Subject: FW: M/68/20/PL- Poultry Farm 87 Yapton Road- Surface Water Drainage Comments

To: Planning.Responses <Planning.Responses@arun.gov.uk>
Cc: Anita Gardner <Anita.Gardner@arun.gov.uk>
Subject: M/68/20/PL- Poultry Farm 87 Yapton Road- Surface Water Drainage Comments

Thank you for consulting us. We have the following comments on surface water drainage.

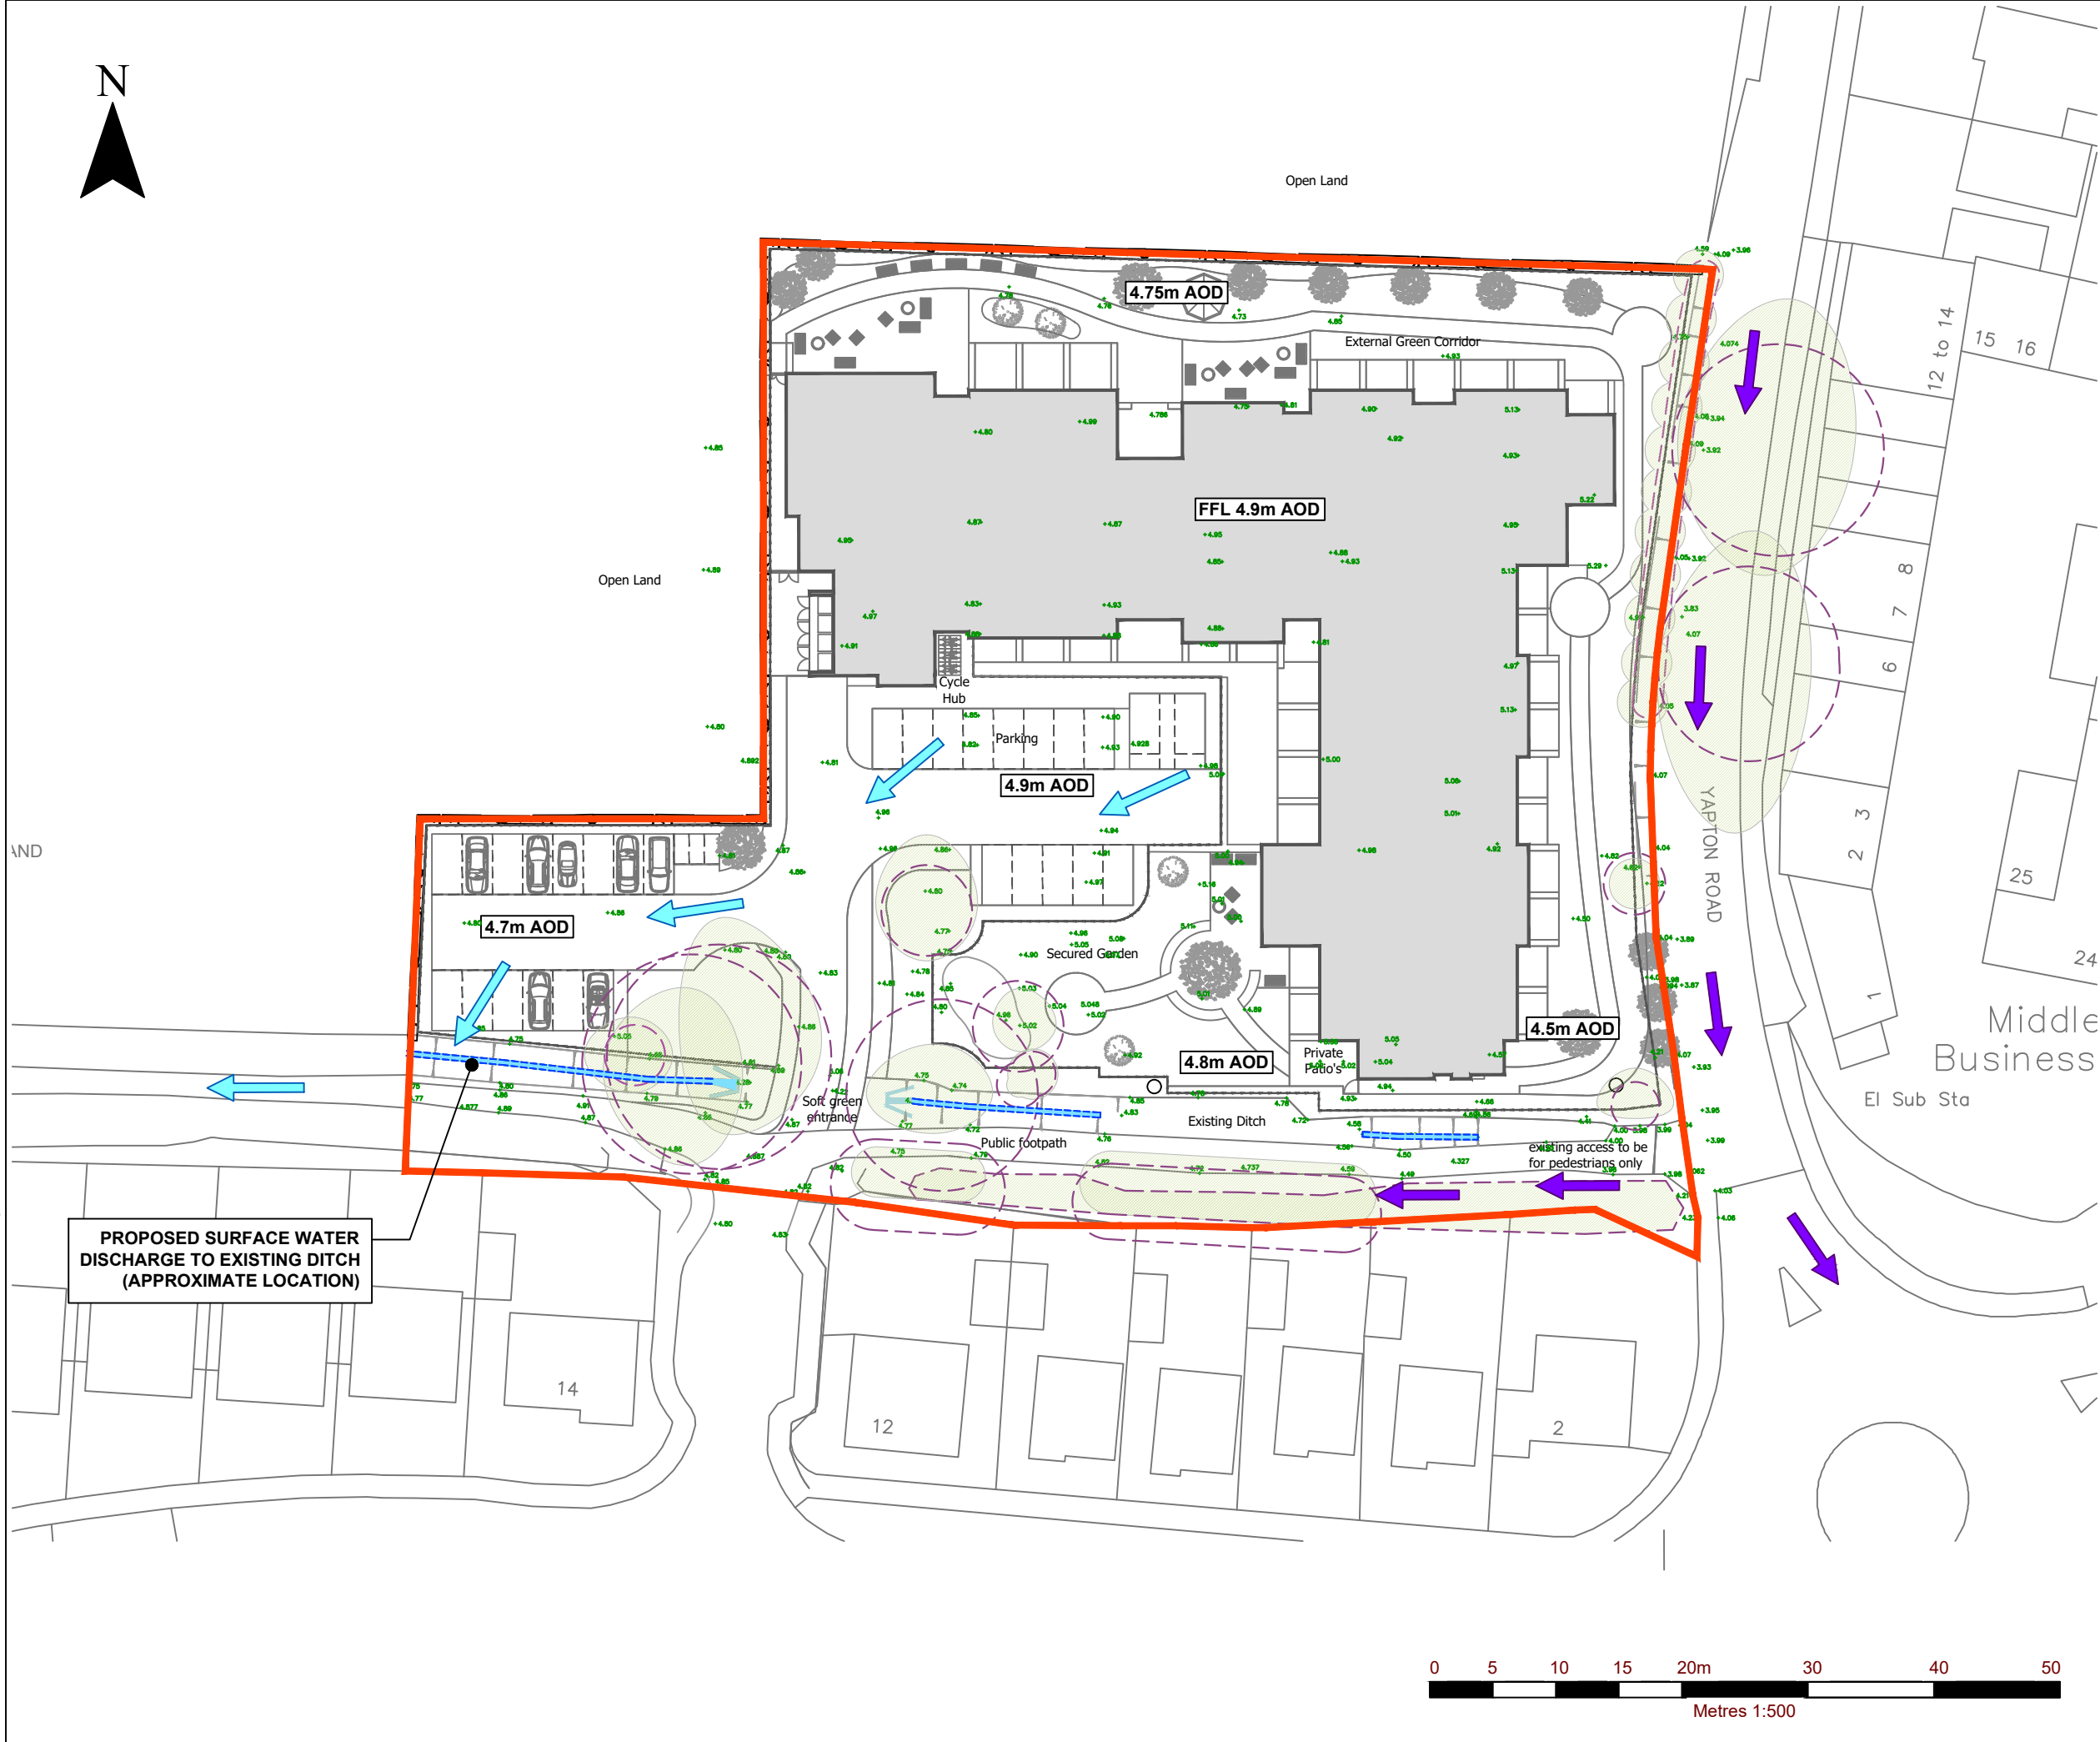
The application is a significant deviation from the previous scheme. Improvements to the drainage network are required. We will also require details of proposed site levels, with differences to existing levels clearly shown. Proposed and Existing topographical levels now clearly marked on SWDS Drawing SWDS 03.

Proposed crates must be kept at least 3m from top of bank of ordinary watercourses Amended on revised SWDS drawing SWDS 03. We have concerns regarding conflict between the draft drainage strategy and trees. Tree Protection Areas now marked, and amended crate layout provided on updated Drawing SWDS 03. On this basis we wish to place a **holding objection** on this application. It has not been demonstrated that there is adequate space within the proposed layout for surface water drainage. It is essential to establish if there is adequate space for surface water drainage prior to agreement of site layout. Drainage should be a fundamental consideration in design. Failure to secure a robustly evidenced implementable drainage strategy at this stage will likely unduly prejudice the drainage design and result in proposals failing to meet policy requirements. Please see amended layout that we consider is deliverable within the site constraints for approval at this concept stage.

Arun DC Drainage Engineer Request	SLR Provision
1. We will require details of proposed site levels, with differences to existing levels clearly shown;	See updated Drawing SWDS 03 attached.
2. Proposed crates must be kept at least 3m from top of bank of ordinary watercourses;	See updated Drawing SWDS 03 attached.
3. Proposed impermeable areas plan,	See updated Drawing SWDS 01 and SWDS 02 attached.
4. A drawing that clearly shows the above and the trees that are to be retained, the root potential areas and the proposed drainage.	See updated Drawing SWDS 03 attached.

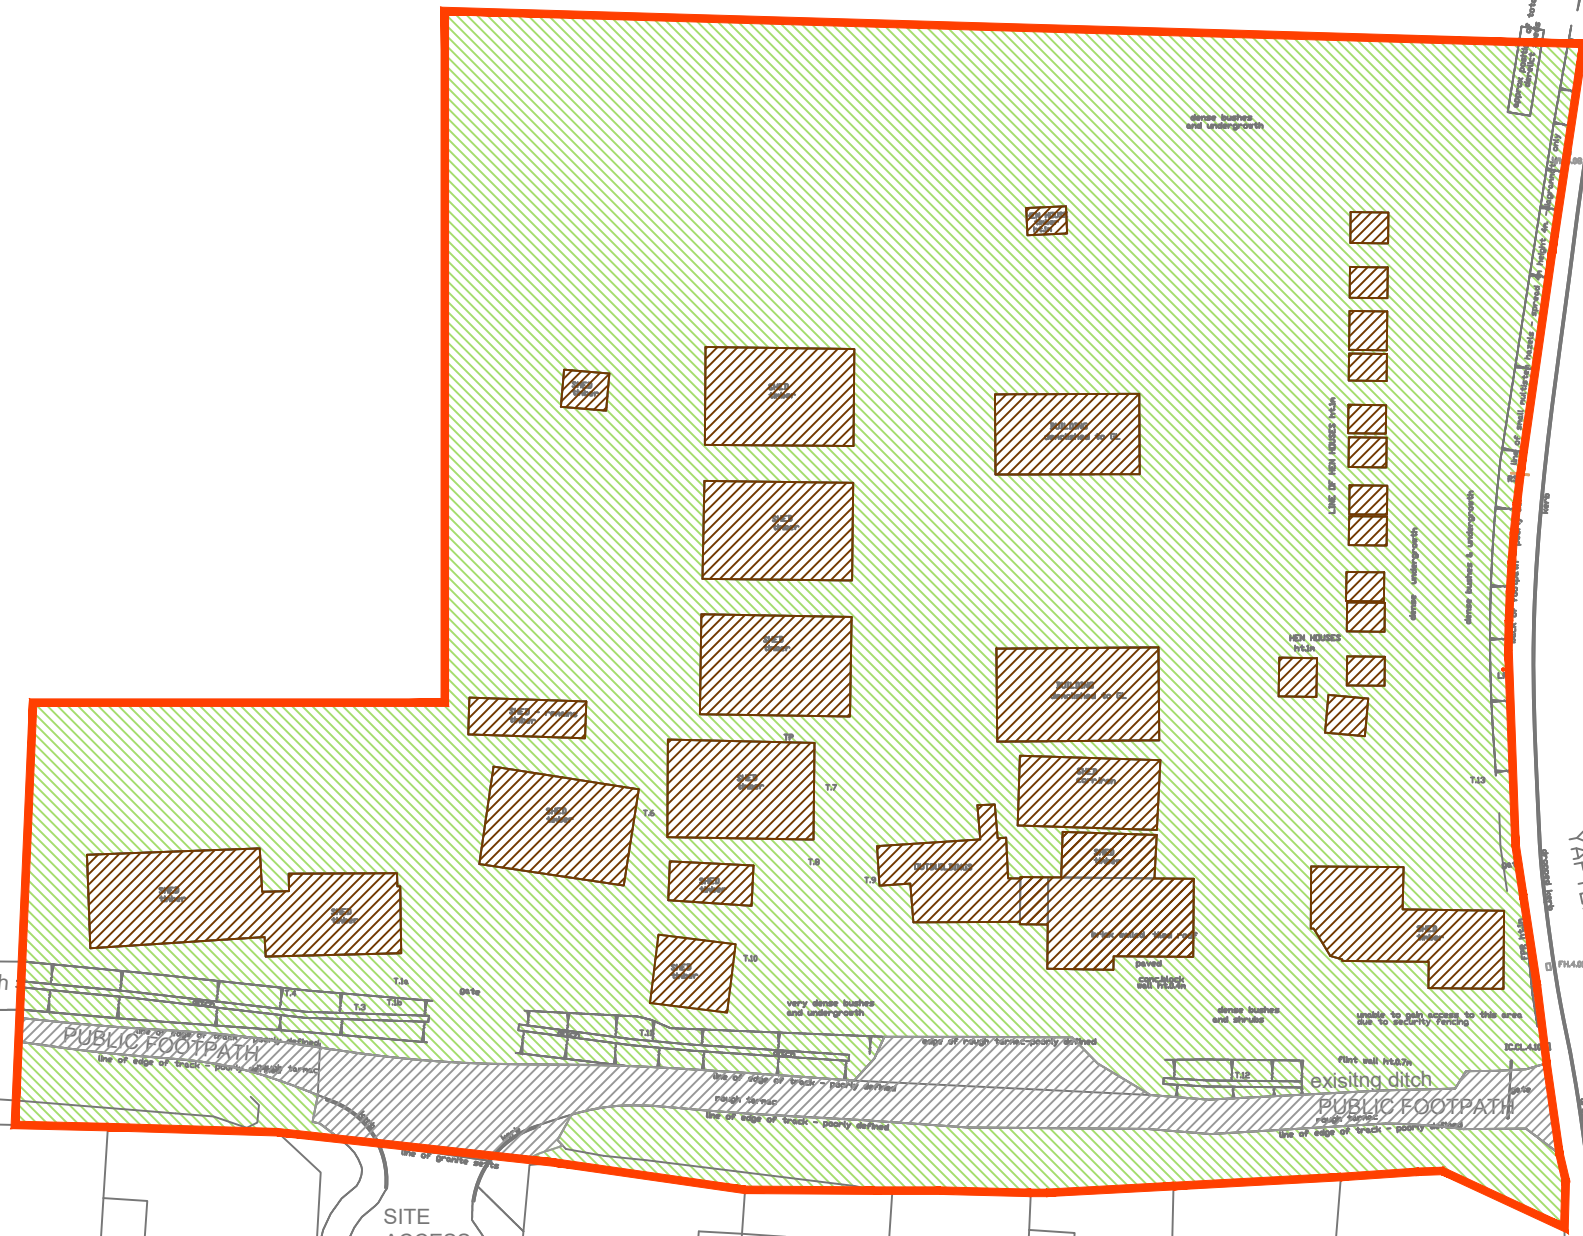
A drawing that clearly shows trees that are to be retained, the root potential areas and the proposed drainage. Please see attached Drawing SW1 that clearly depicts retained trees and their root protection areas clearly marked for approval.
